# Planning Non-Material Variation Service: Request Form

42 grange road, edinburgh

21/04296/ful  
21/04296/vary

STATUS	NMV
CLIENT	SURABHI AND MAHESH
PROJECT	42 GRANGE ROAD EDINBURGH
TITLE	AS PROPOSED SITE ALTERATIONS
DRAWN	JOB No. / Drwg No. / Rev
LB LB	0286 / P04 / N
SCALE DATE	@A3 FEB 21

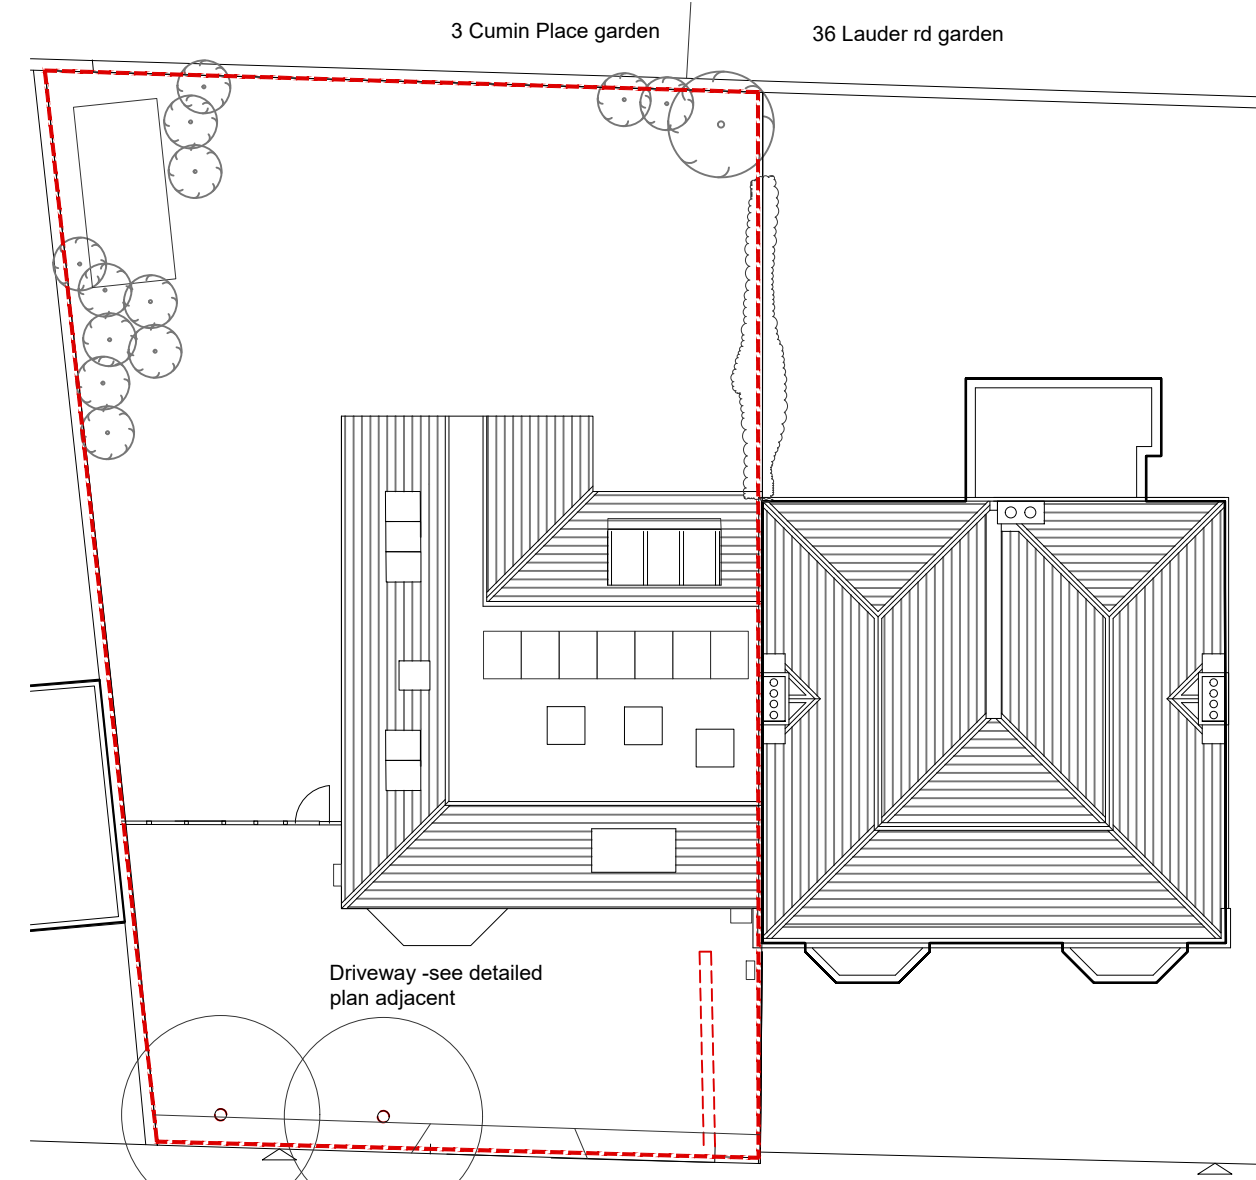
This variation refers to drawing number 0286 P04 driveway rev E from original application which requested the driveway opening be moved to the west of the original.

The driveway opening is to be retained in the original position. A new sliding electric gate is to be installed alongside a new pedestrian gate to match. Drawing P04 driveway rev N.
